THE  STAR

MODIFICATION 13 PLANNING SUBMISSION

NATIONAL CONSTRUCTION CODE (BCA) REPORT

title
General Arrangement Plans
Level 07 Floor Plan

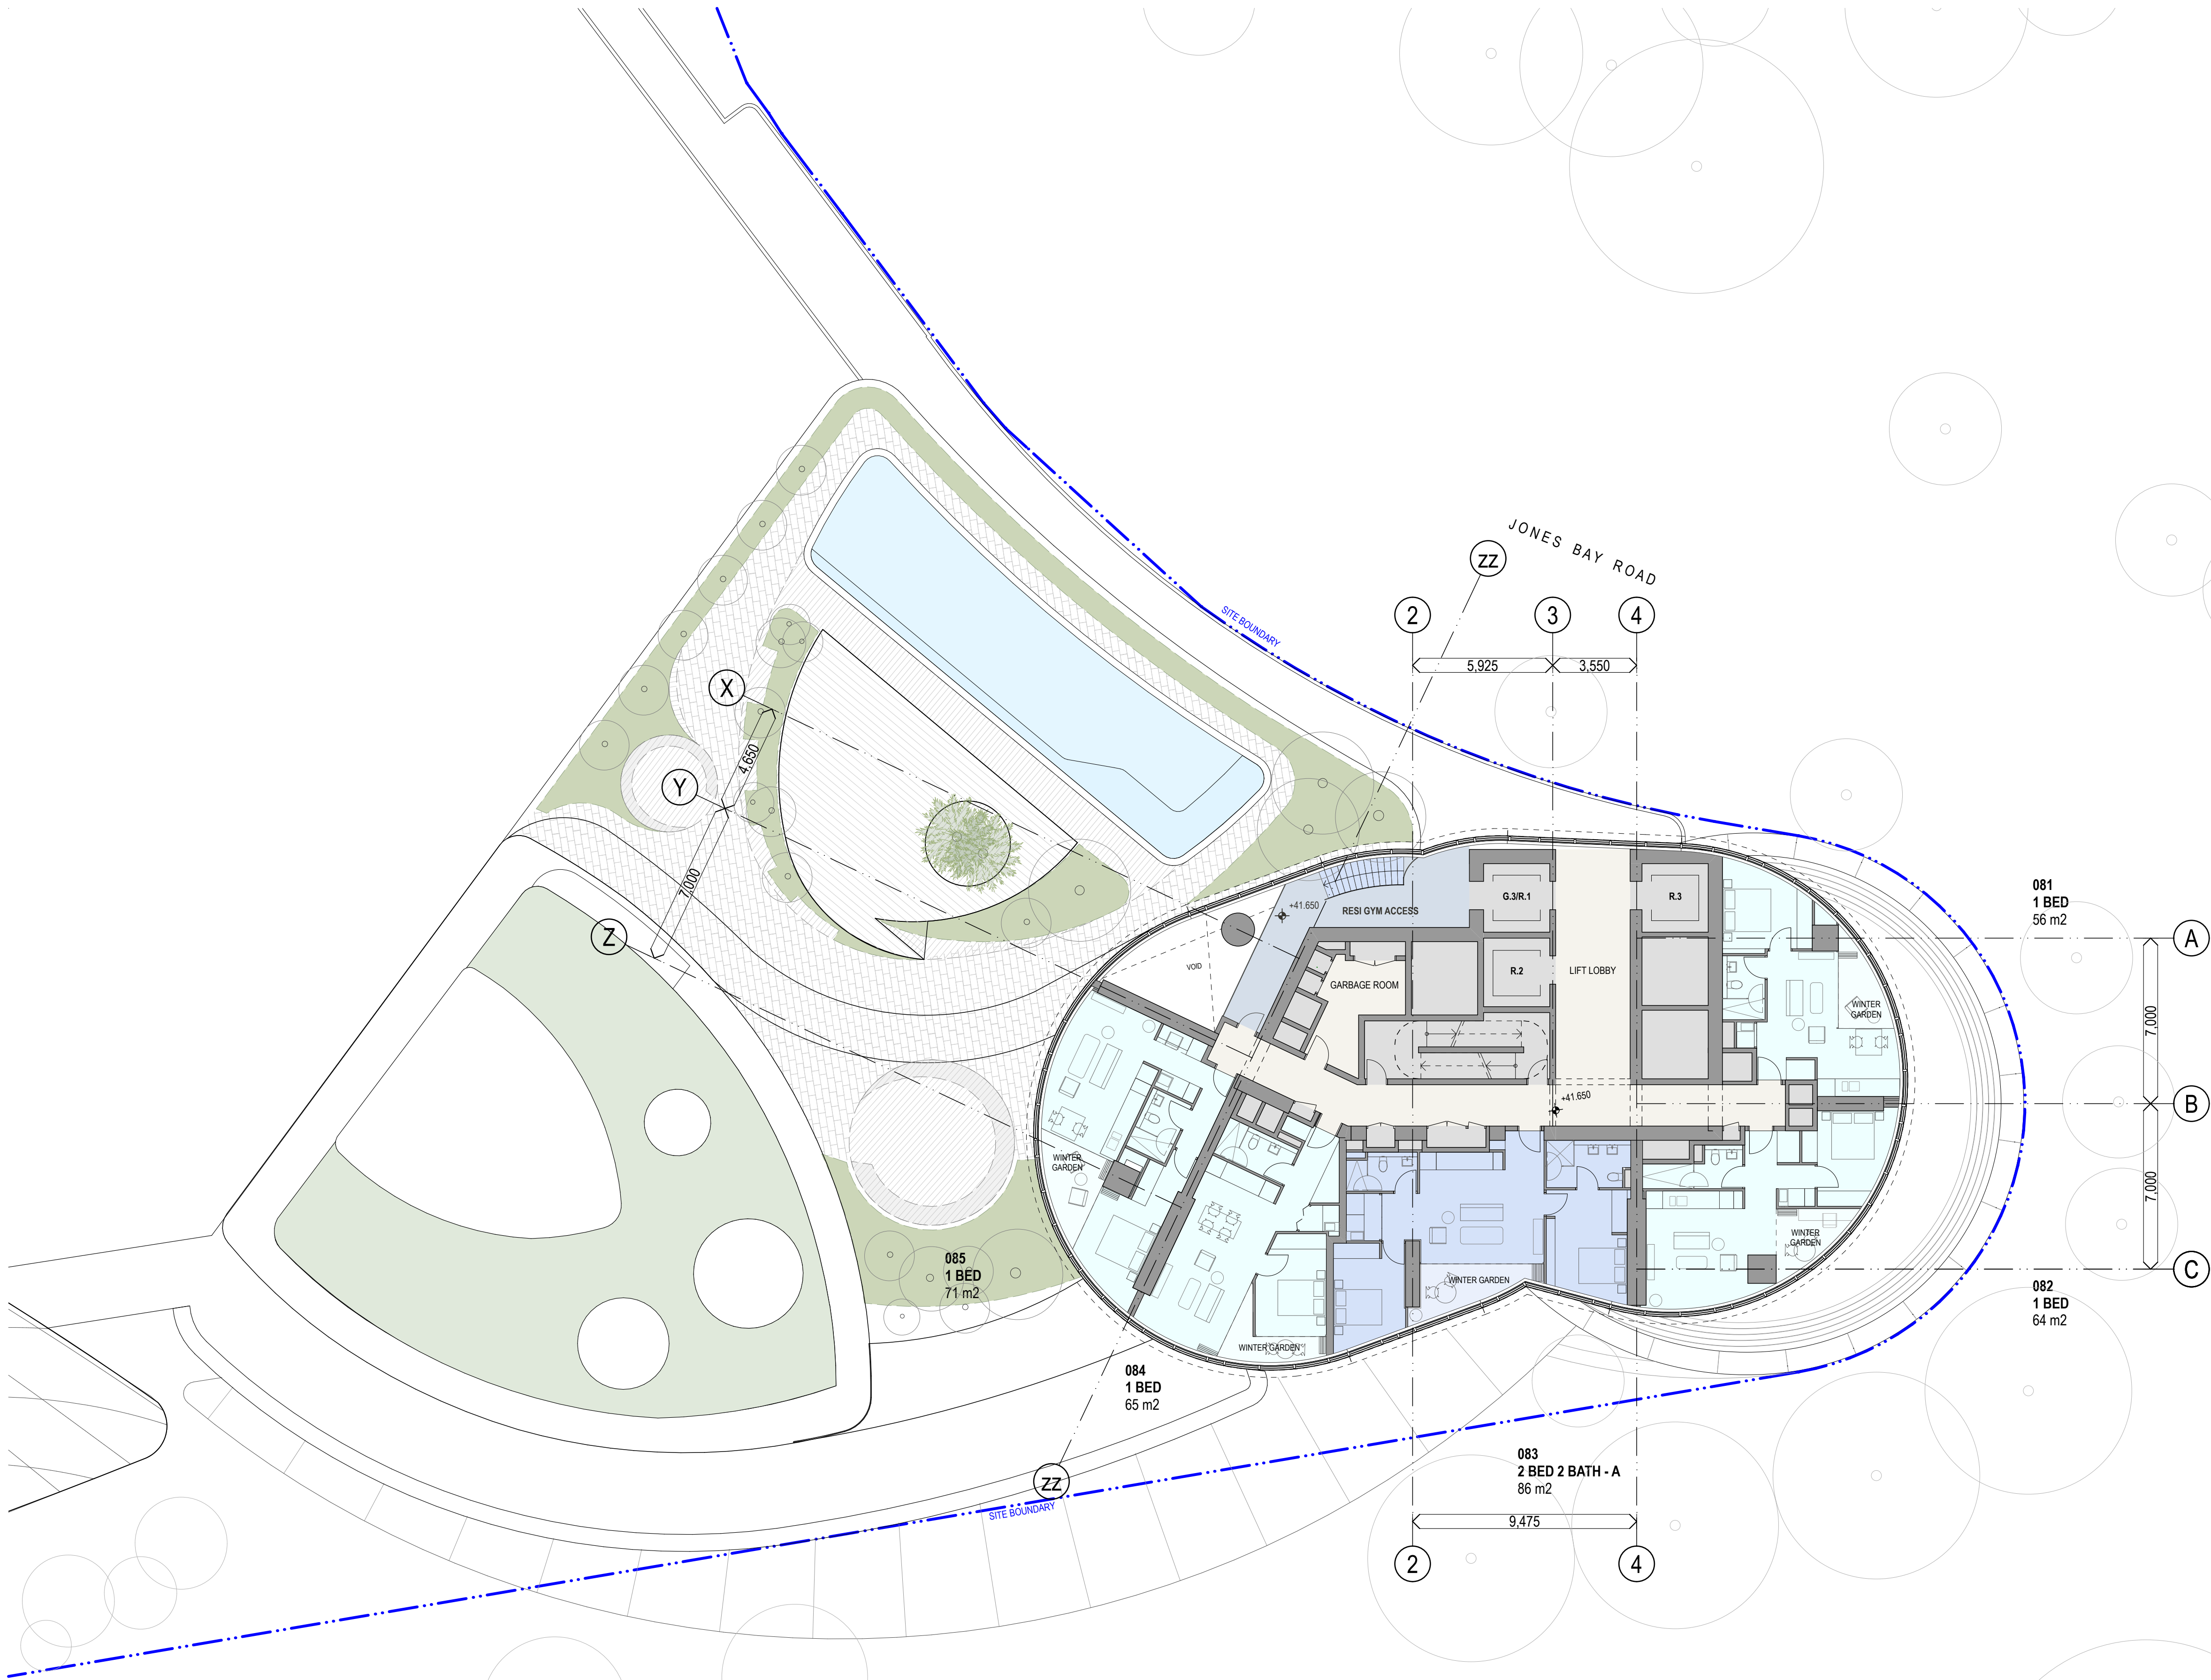
Level 7

- Travel distance to a point of choice 26m in lieu of 20m in hotel gym
- Travel distance to an exit after a point of choice 51m in lieu of 40m

Level 7

- Distance between alternative exits 100m in lieu of 60m

The fire engineered solution relating to EP2.2 & EP1.6 will need to be approved after consultation with the NSW Fire Brigade as part of the Construction Certificate process. The above items are proposed to be assessed by WSP Fire Safety Engineering as documented in the Concept Fire Safety Strategy.

title
General Arrangement Plans
Level 09 Floor Plan

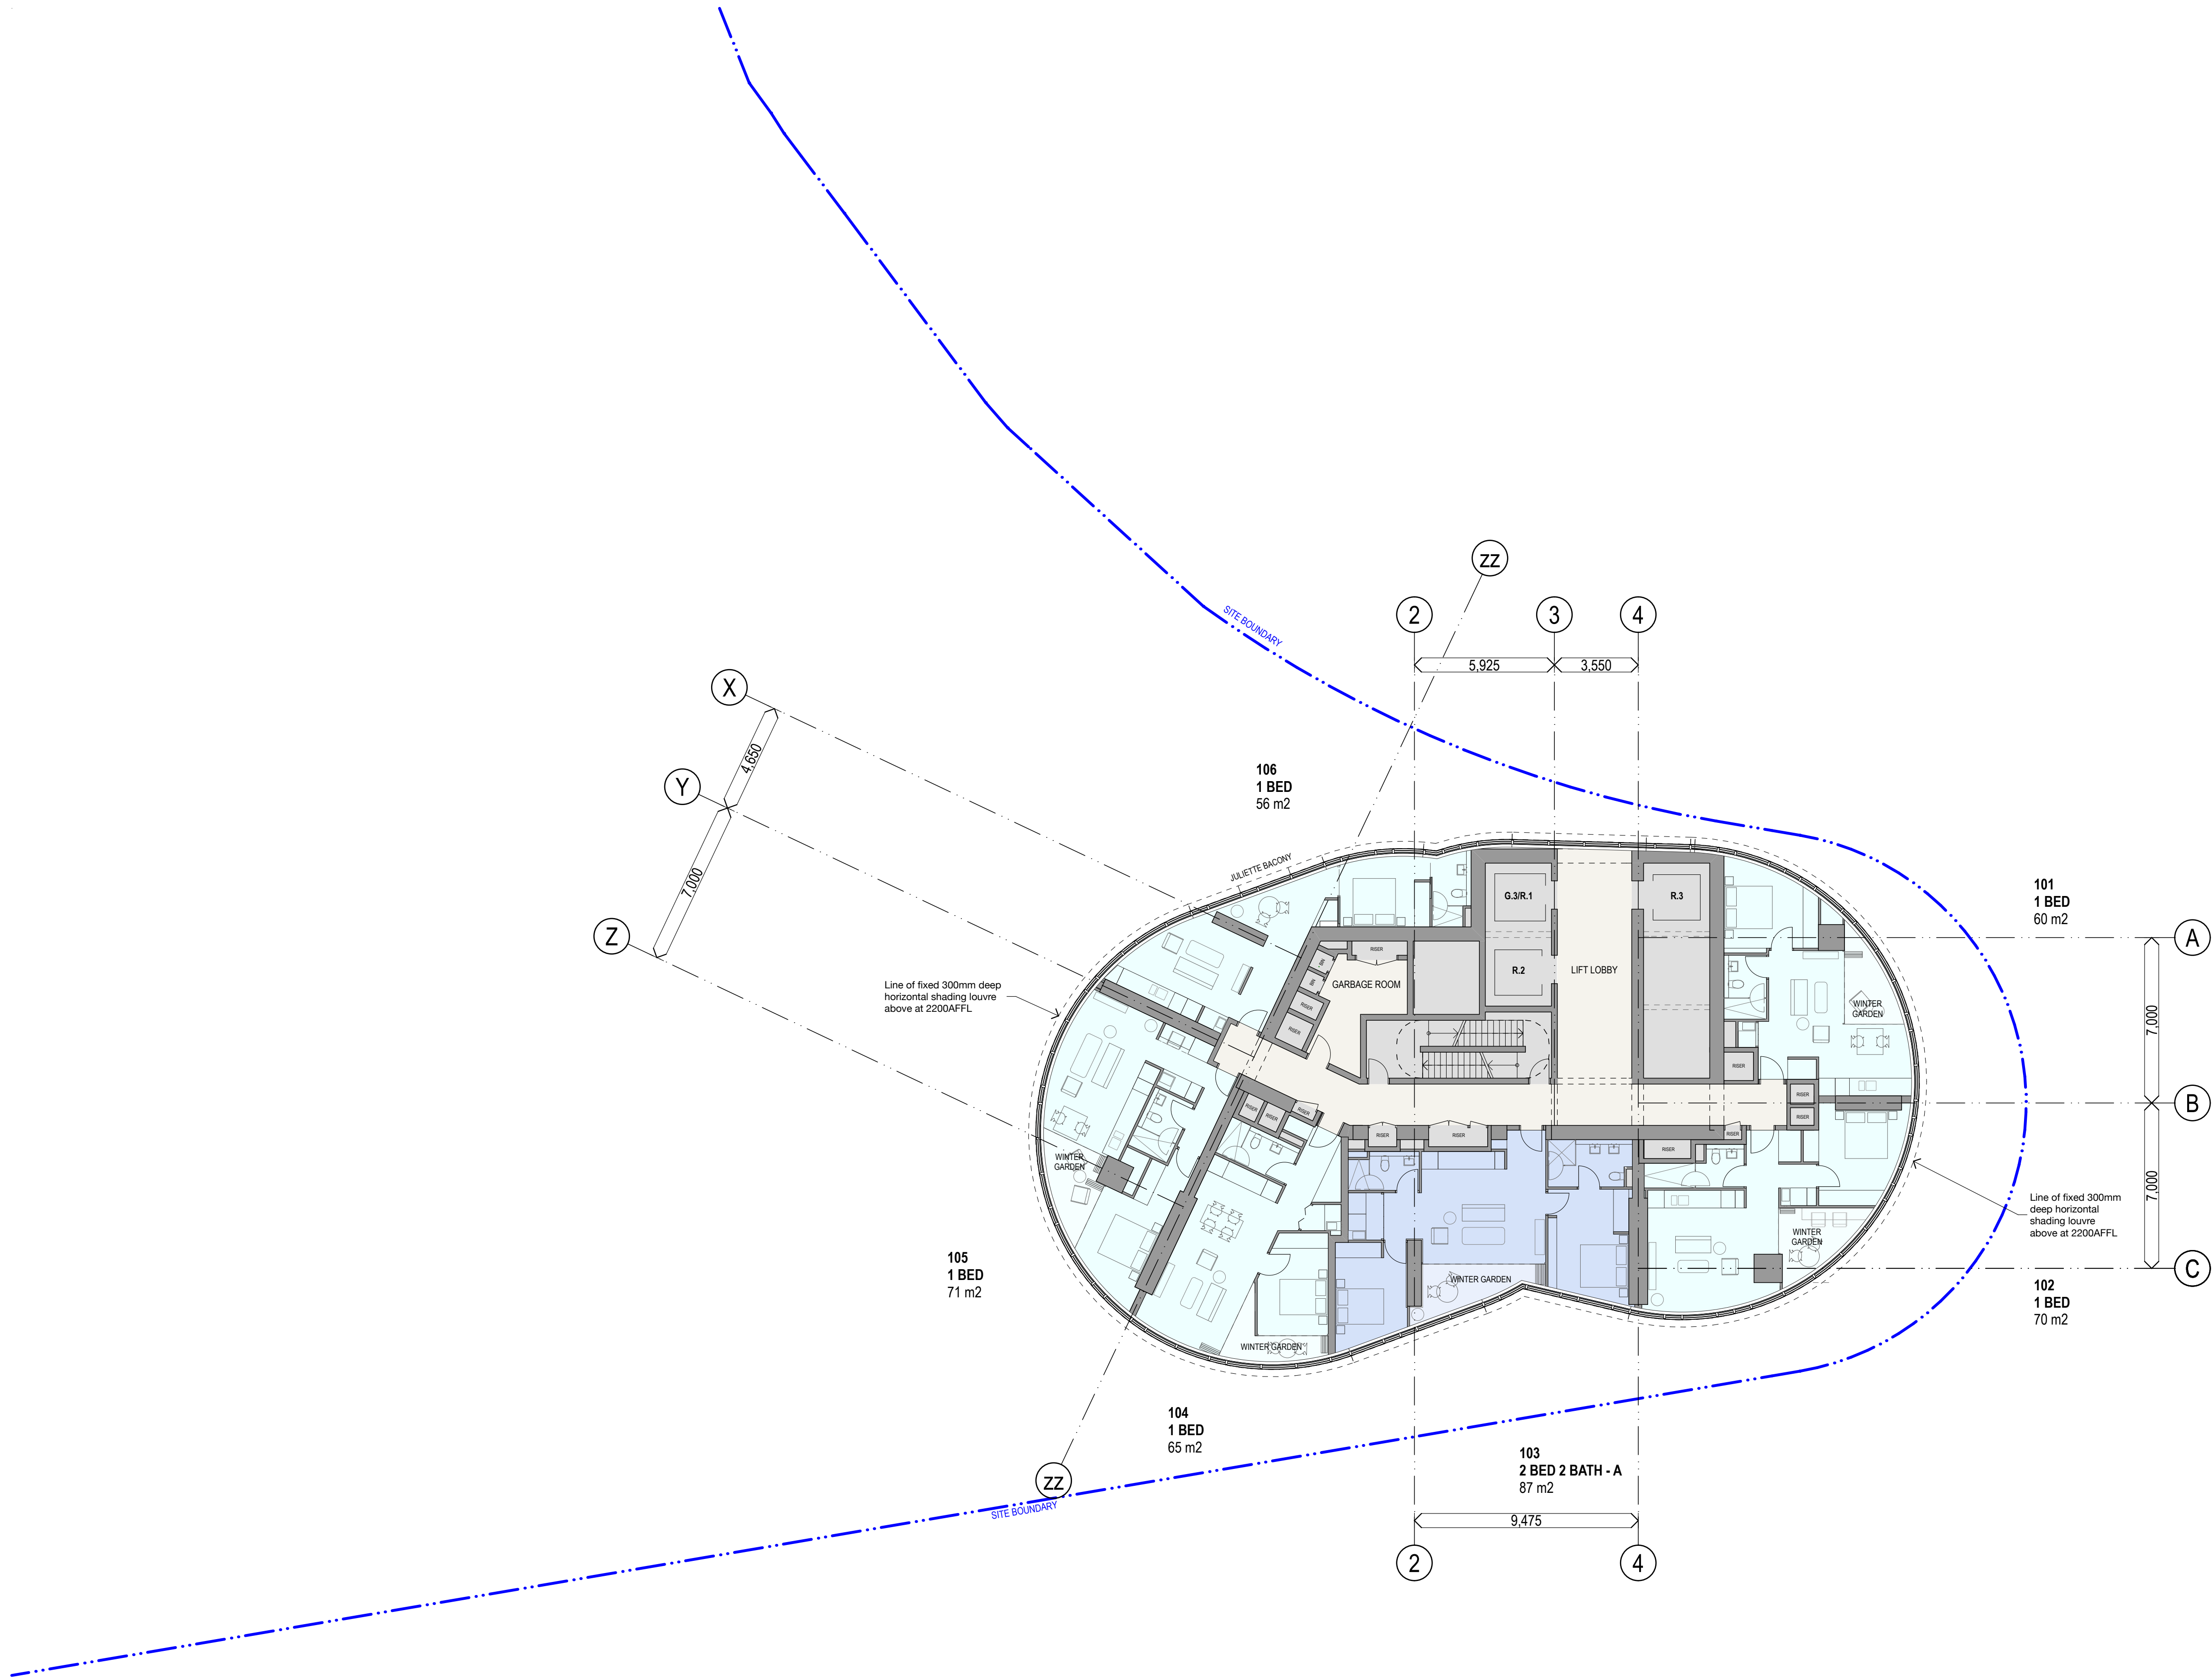
Level 9

- Travel distance to a single exit 52m in lieu of 20m from residential pool area

Level 9

- Distance between alternative exits 110m in lieu of 60m
- Distance between exits 6.5m in lieu of minimum 9m
